Nottinghamshire County Council
Addendum to Local Impact Report (Flood Risk)
One Earth Solar Farm EN010159

3. In its capacity as the LLFA, NCC has commissioned AECOM to review the applicant's Flood Risk Assessment (FRA) and Drainage Strategy for the One Earth Solar Farm (NSIP EN010159). The review evaluates the FRA and surface water drainage strategy, examining the methodology and consistency with relevant policies and guidance. It also assesses the potential impact on local flood risk, considering flood risk from surface water, ordinary watercourses and groundwater.

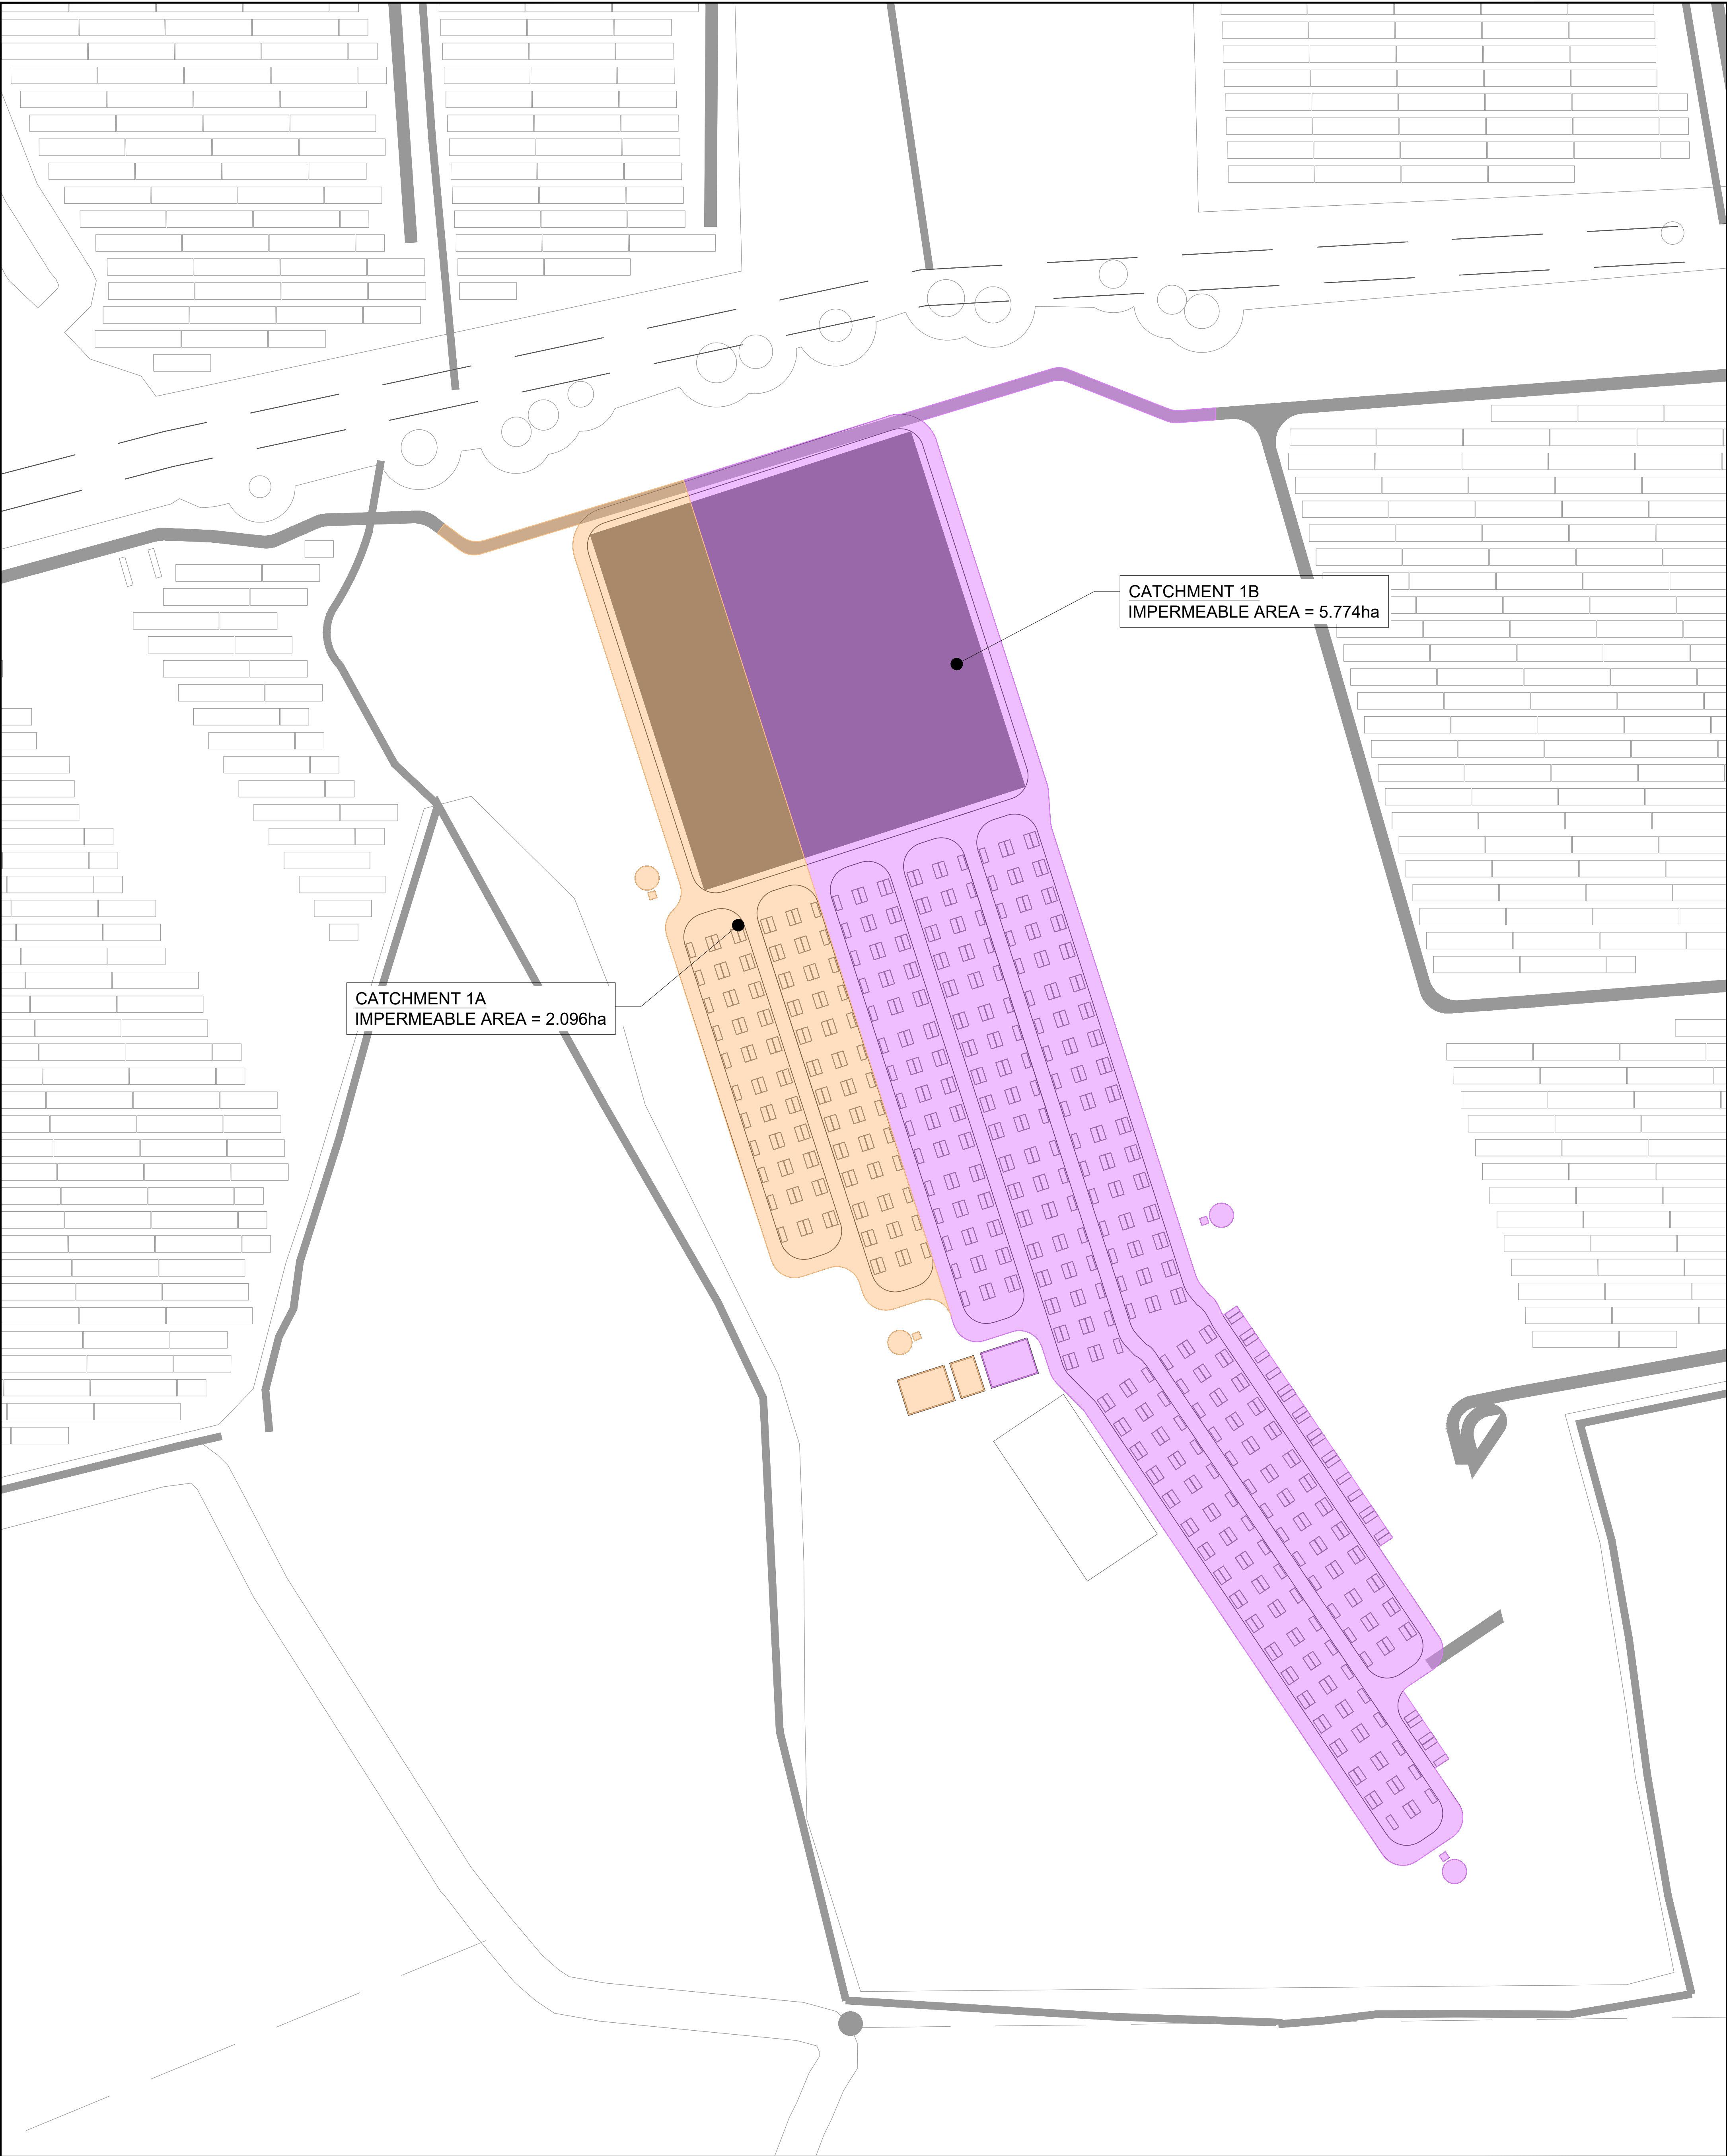
- d) The applicant needs to confirm that the access track catchment has been explicitly included in the hydraulic modelling and pollution mitigation strategy; if necessary, the applicant should also assess the need for additional SuDS features or ditch capacity to accommodate runoff.

- g) Greenfield runoff rates have been calculated using the ICP SuDS method. FEH methods are typically preferred however this method is commonly used. However, it is unclear whether the LLFA's request to account for the hydraulic contribution of the access track (7m indicative width) has been incorporated into the catchment modelling.

Drawing Title:
Surface Water Drainage Strategy
Western BESS Compound

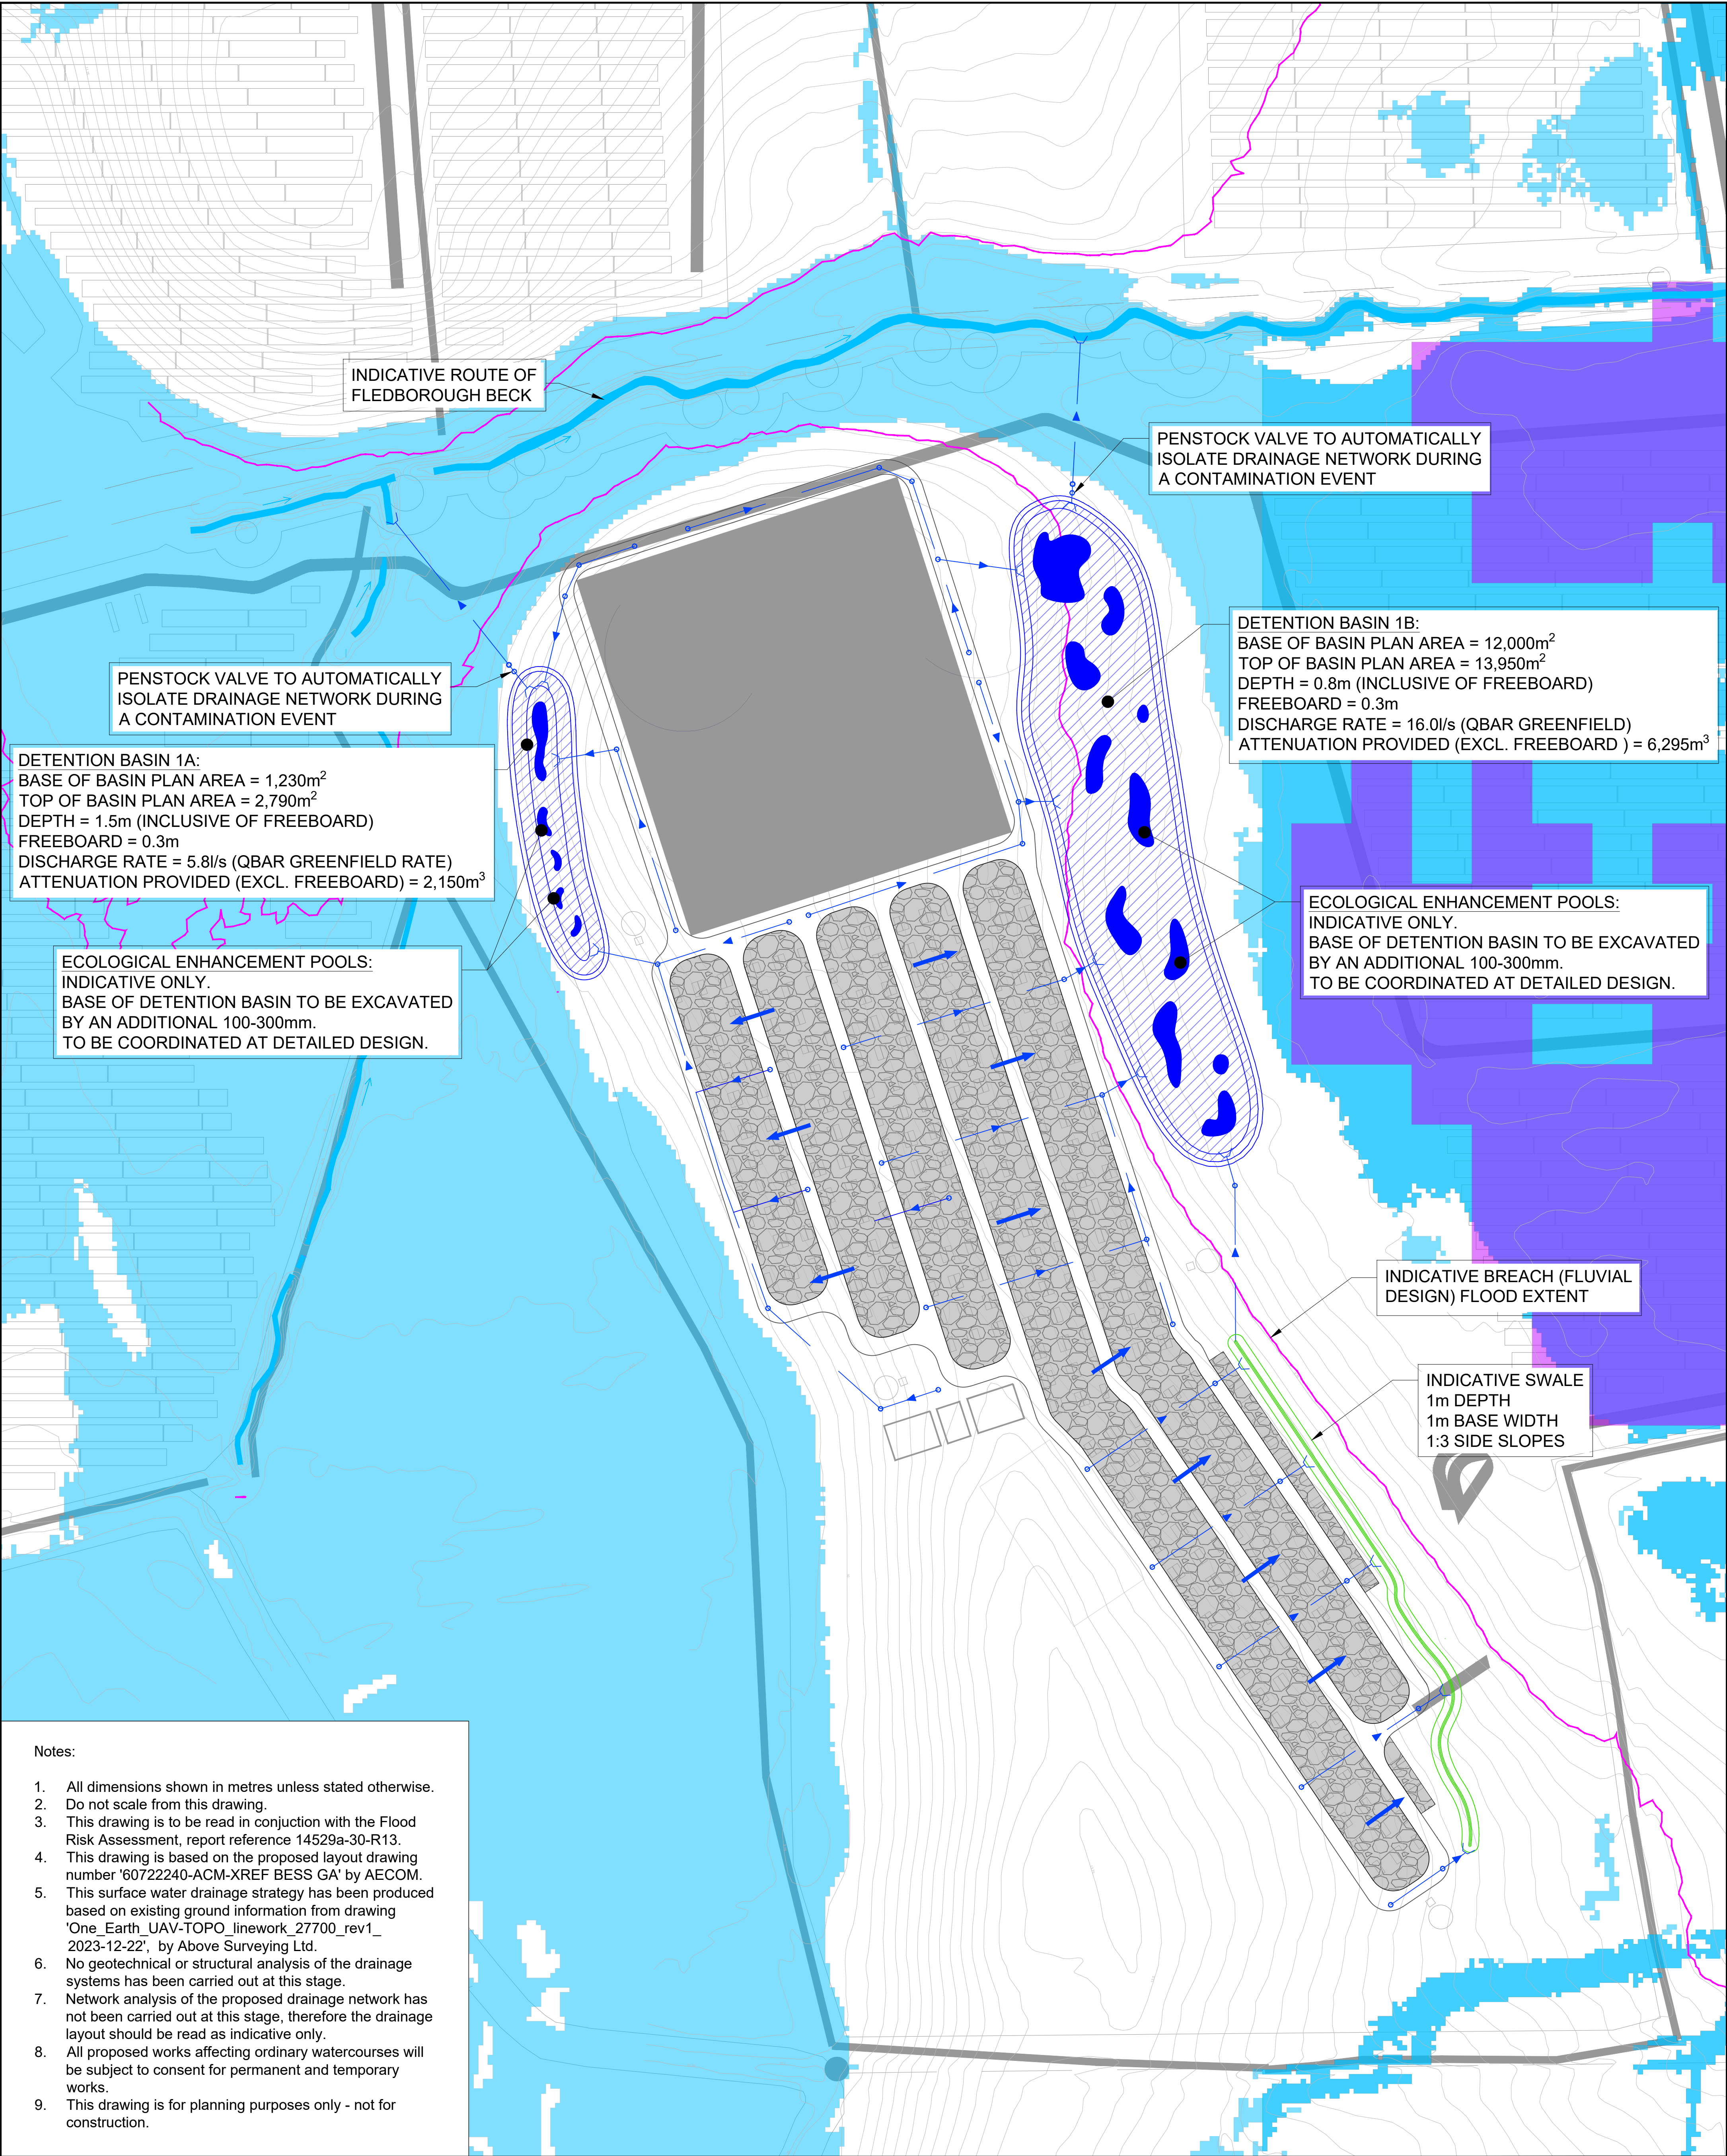
- e) The attenuation modelling is based on FEH 2022 rainfall data and a 40% climate change uplift. Basin depths, freeboard and flow control arrangements appear suitable for the planning stage but the design does not achieve half drain within 24 hours.

- f) For the attenuation calculations, runoff coefficients of 0.75 (summer) and 0.84 (winter) for impervious areas are used. The drained areas are stated to be 100% impermeable and therefore a higher value closer to 1.0 would give a more accurate estimate in line with actual site conditions

- h) Exceedance flow routes are described in principle but are not presented via a drawing or diagram. A site wide exceedance route plan is recommended to show how flows will be directed away from sensitive infrastructure using swale corridors and low points towards discharge points, especially where surcharging may occur.

Drawing Title:
Figure 7.2: Existing Watercourses

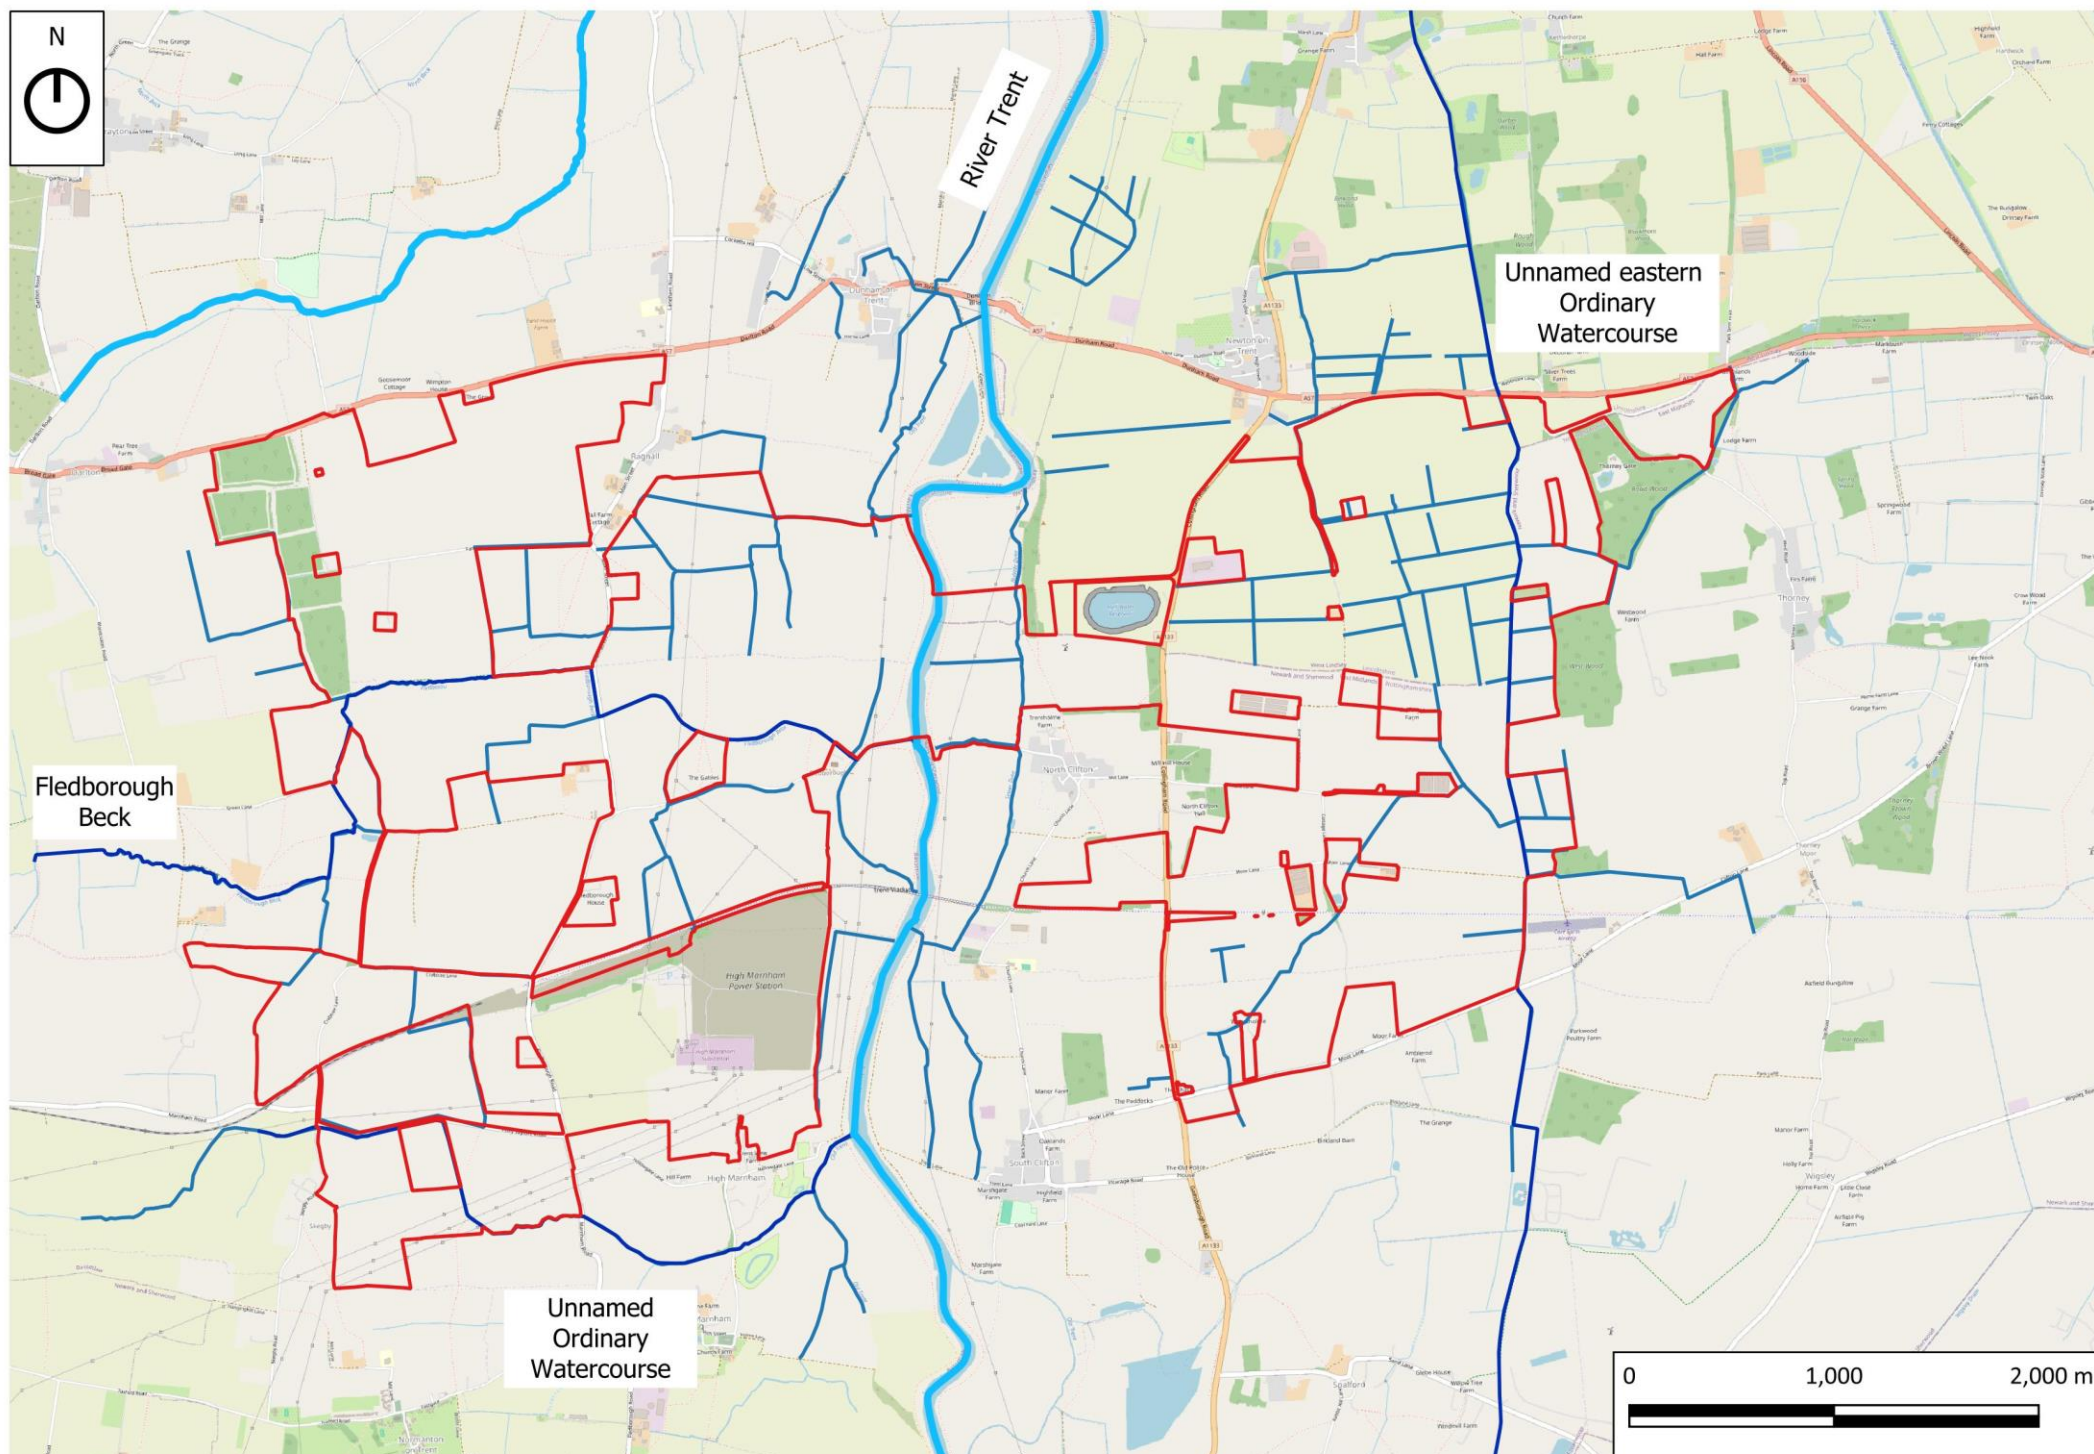
- c) The document provides only a general overview of site drainage and lacks detailed information on existing infrastructure; inclusion of a plan clearly marking existing drainage features such as ditches, watercourses or crossing points would offer clarity.
